Planning Application Reference No.: 3/2026/0452

Address of Development: 3a swan courtyard castle street clitheroe bb72dq

From: [REDACTED] >
Sent: 17 August 2026 16:46
To: Planning
Subject: Re appln 3/2026/0452

drawing:
Proposed Elevations

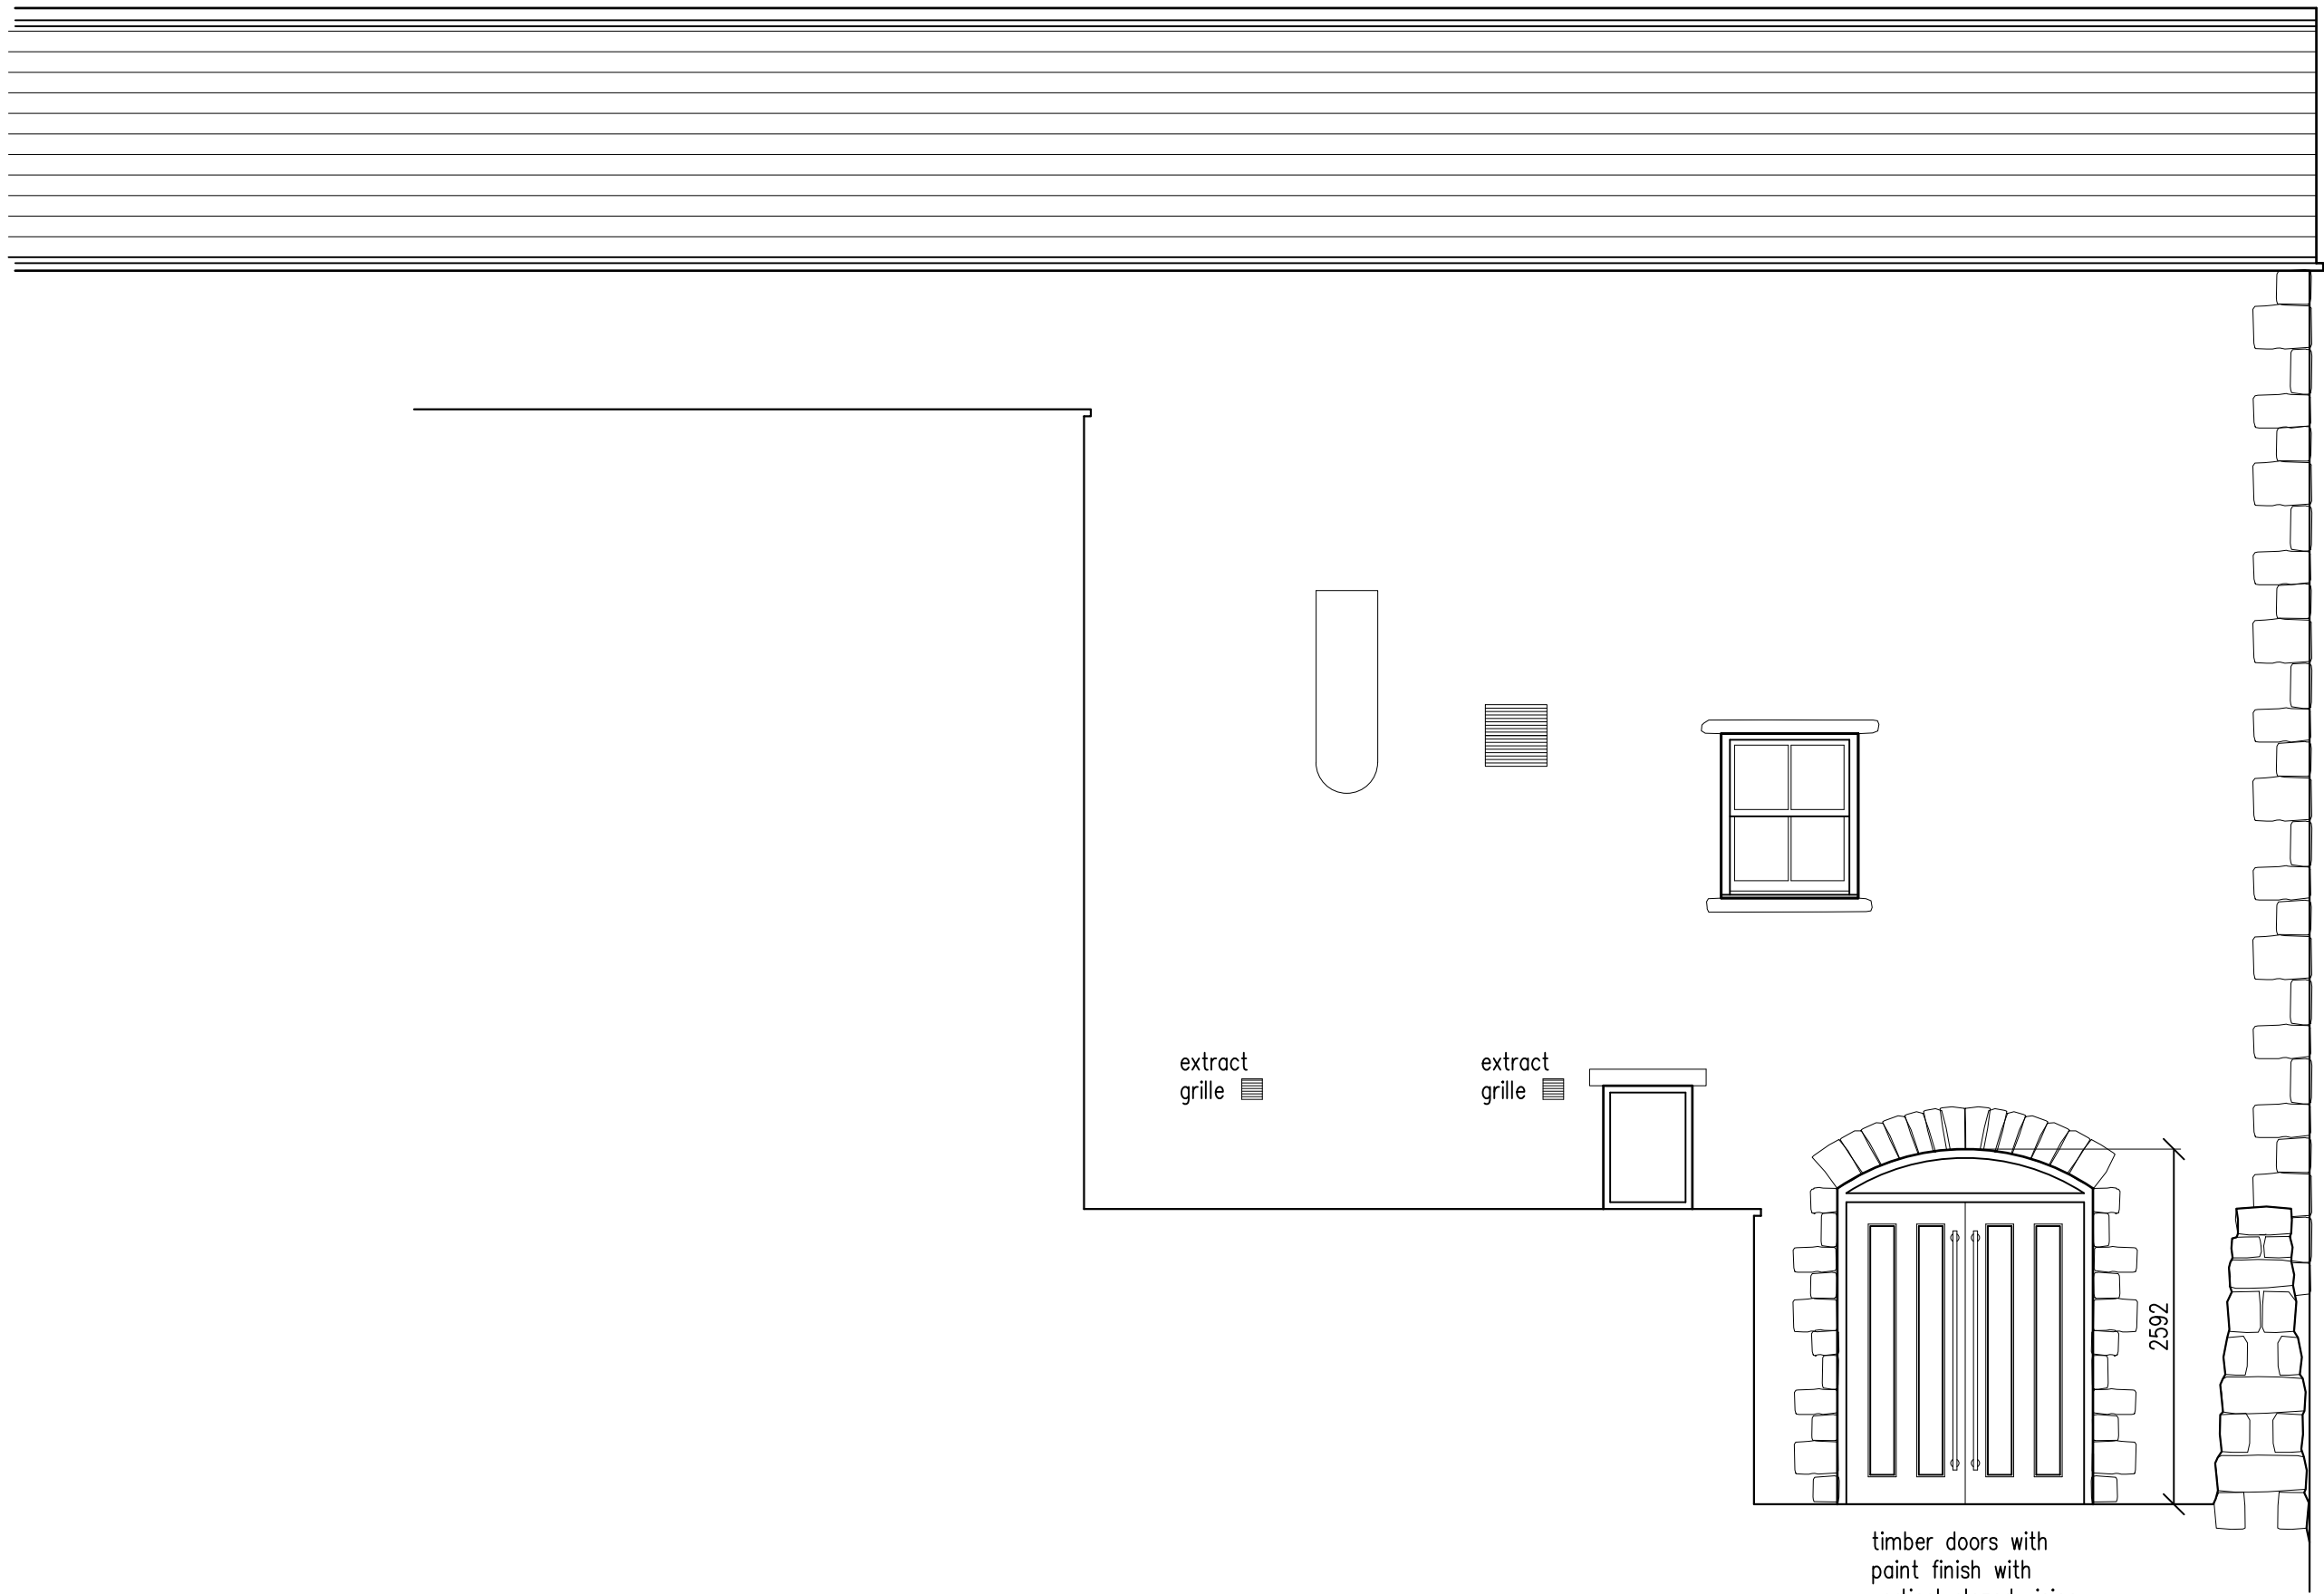
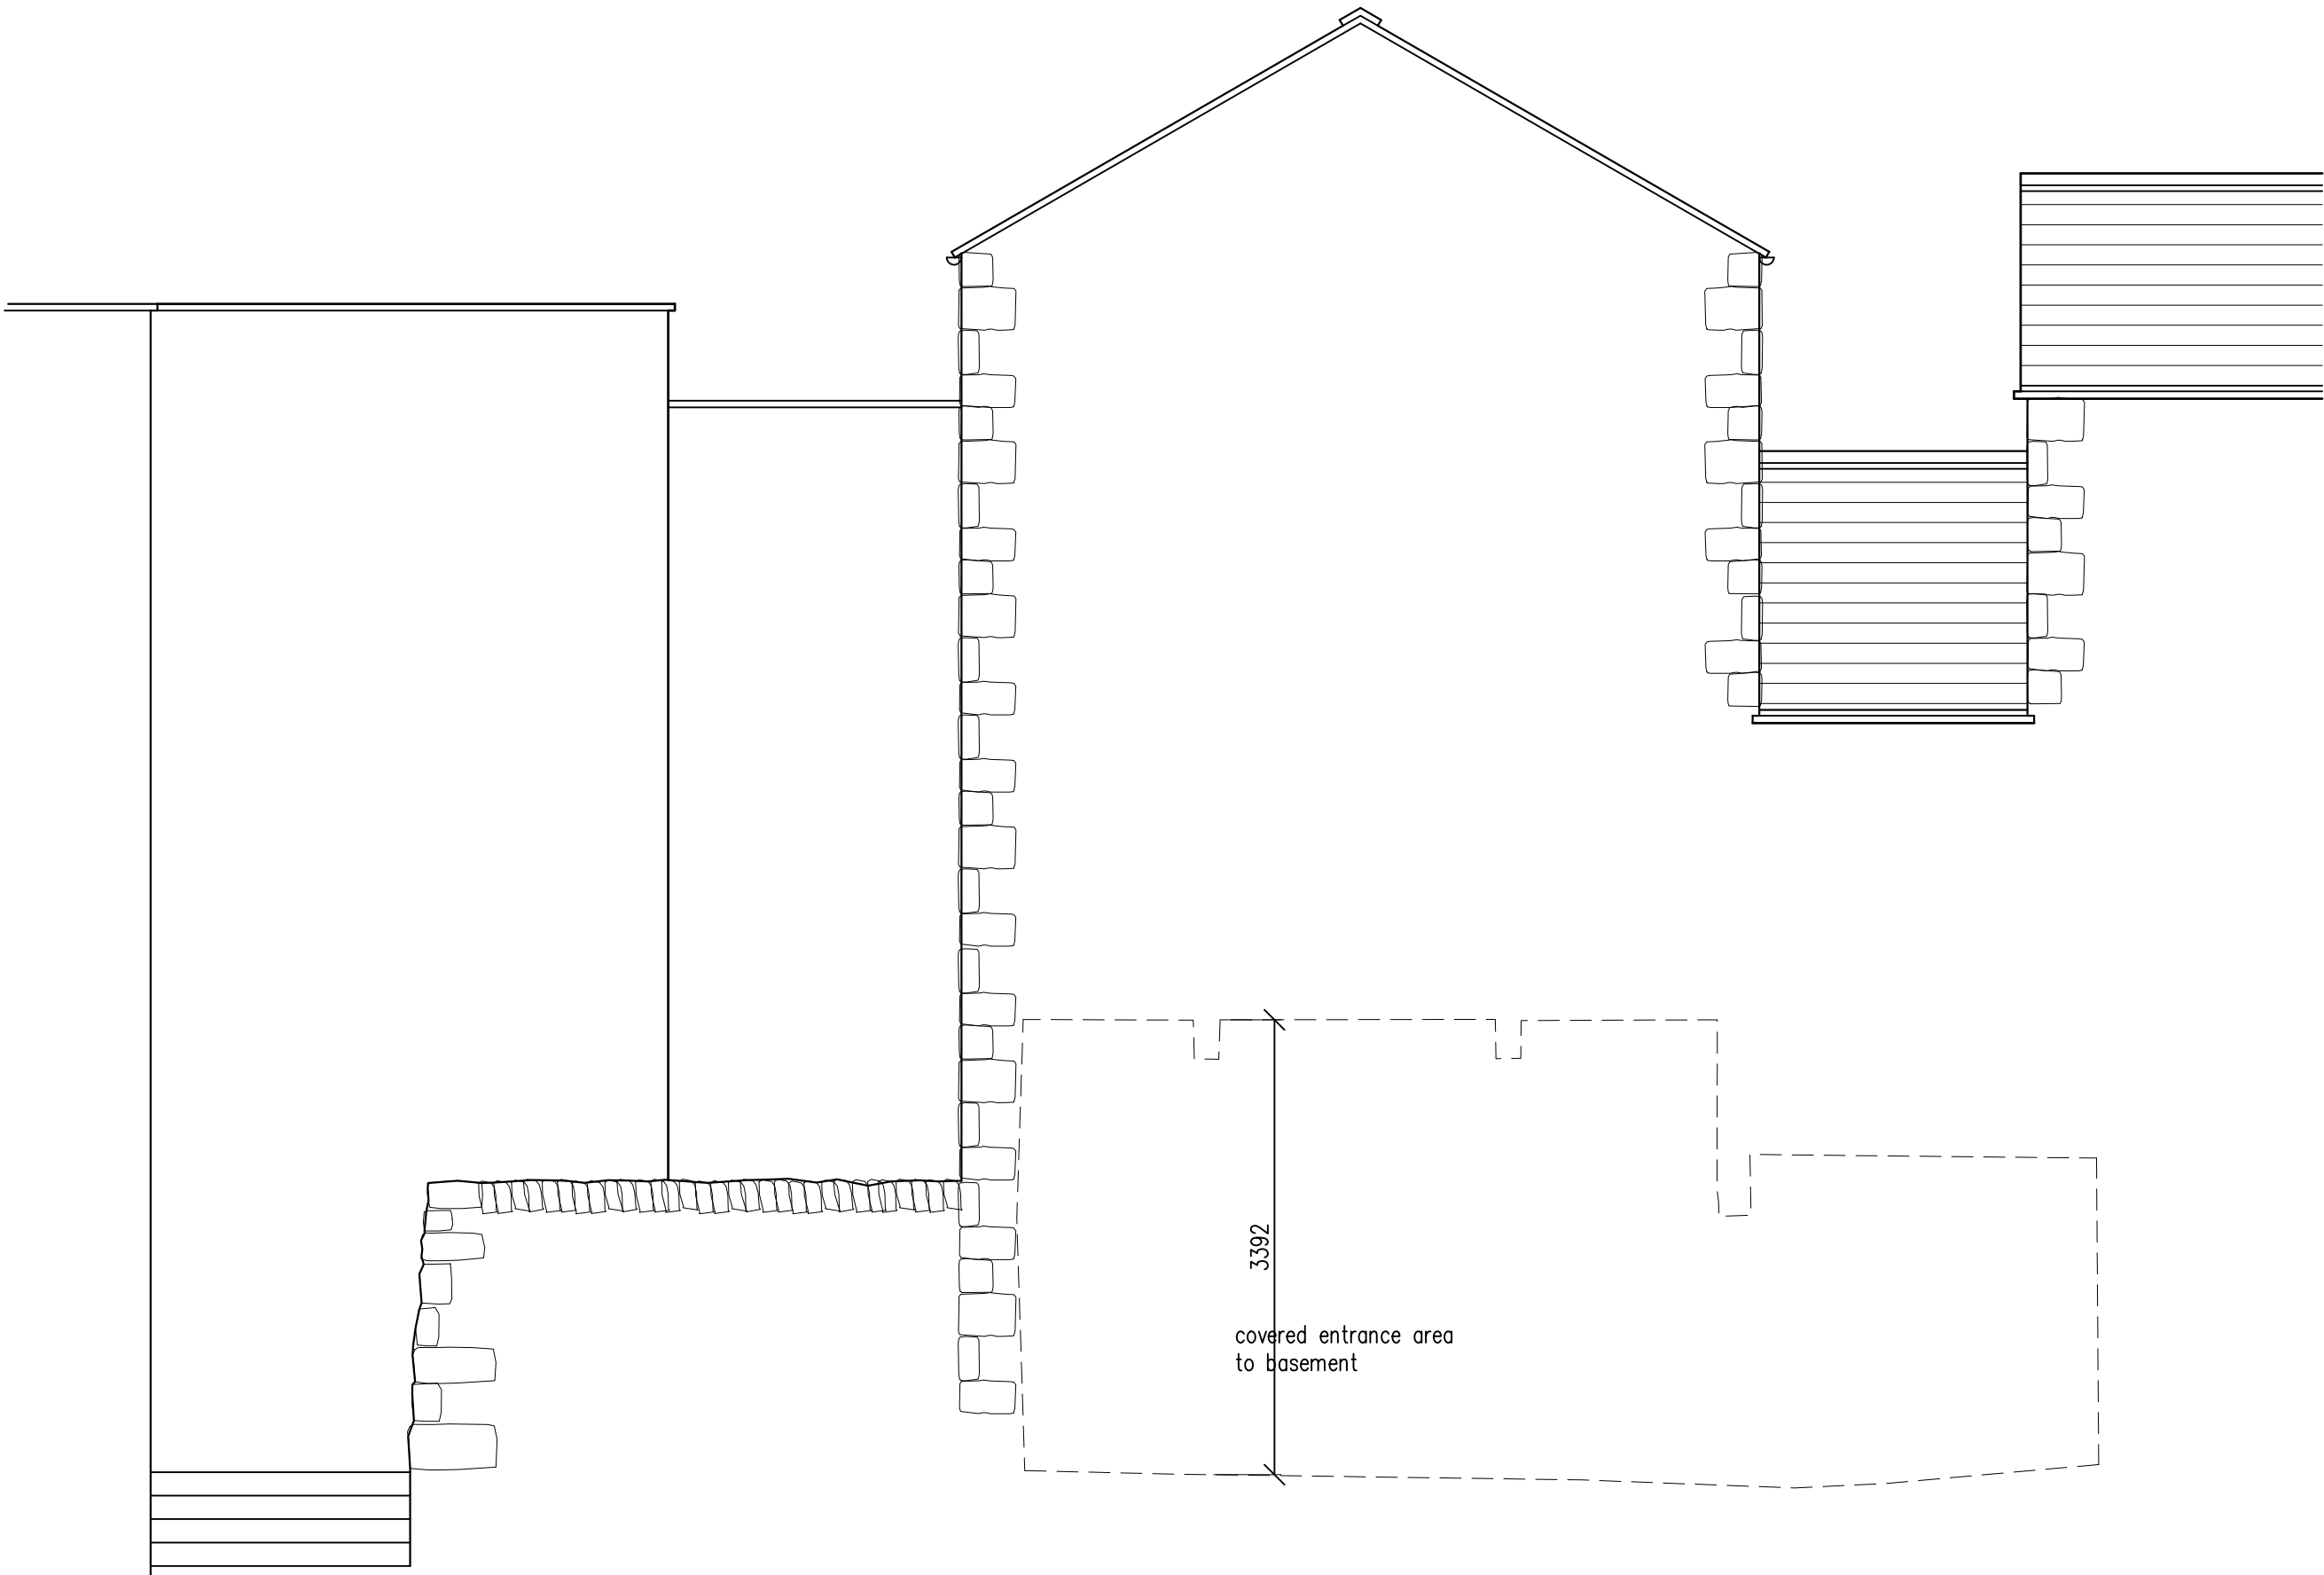
We note that individual extractor fans will be present for the new male and female loos - however plans should still detail the location and scale of these for planning consideration.
